CITY OF PORTLAND BUILDING PERMIT

Job ID: 2012-02-3230-CH OF USE

has permission for Phase II, Interior renovations/ Change of Use- Single Family to Two (2) Family Residence..
provided that the person or persons, firm or corporation accepting this permit shall comply with all of the provisions of the Statues of Maine and of the Ordinances of the City of Portland regulating the construction, maintenance and use of the buildings and structures, and of the application on file in the department.

475 Brighton Ave Unit A Condo Conversion – RFI answers

475 BRIGHTON AVE UNIT A

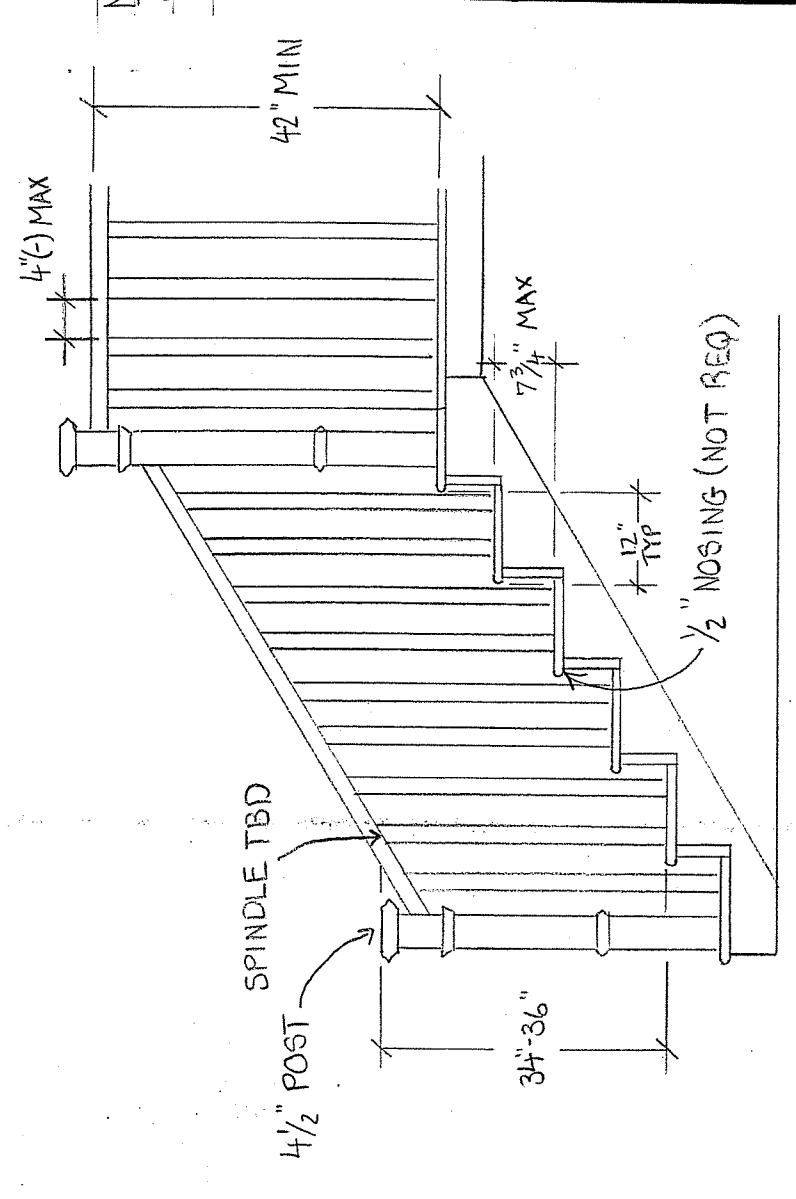
(Mark on Plans) Window sills in locations more than 72 inches from finished grade shall be a minimum of 24 inches above the finished floor of the room, unless a window fall prevention devices is installed in accordance with section R612.3.

Emergency Escape (Mark on Plans)

- R310.1 Emergency escape and rescue required. Basements, habitable attics and every sleeping room shall have at least one operable emergency escape and rescue opening.
- A code compliant emergency escape shall be provided in each bedroom. Window sills in locations more than 72 inches from finished grade shall be a minimum of 24 inches (no higher than 44 inches) above the finished floor of the room, or in compliance with Section R612.4.2 Operation for emergency escape.

Stairs (Cross-Section Needed):

- Winder treads shall have a minimum tread depth of 10 inches measured between the vertical planes of the foremost projection of adjacent treads at the intersections with the walkline. Winder treads shall have a minimum tread depth of 6 inches at any point within the clear width of the stair. Within any flight of stairs, the largest winder tread depth at the walkline shall not exceed the smallest winder tread by more than 3/8 inch.

- Stairway headroom shall be not less than 6 feet 8 inches measured vertically from the sloped plane adjoining the tread nosing or from the floor surface of the landing or platform.

Interior Bearing Walls (Cross-Section Needed):

- Girder and Header spans for interior bearing walls shall comply with TABLE R502.5(2)

Unit Separation (Mark Plans)

R302.3 Two-family dwellings. *Dwelling units in two-family dwellings shall be separated from each other by wall and/or floor assemblies having not less than a 1-hour fire-resistance rating when tested in accordance with ASTM E 119 or UL 263. Fire-resistance-rated floor/ceiling and wall assemblies shall extend to and be tight against the exterior wall, and wall assemblies shall extend from the foundation to the underside of the roof sheathing.*

Plans have been marked to label all Egress windows and give the sill height above finished floor. If finished sill height is less than 24" AFF because of existing conditions or dimensional limitations, window fall prevention devices will be installed

Addressed in previous question.
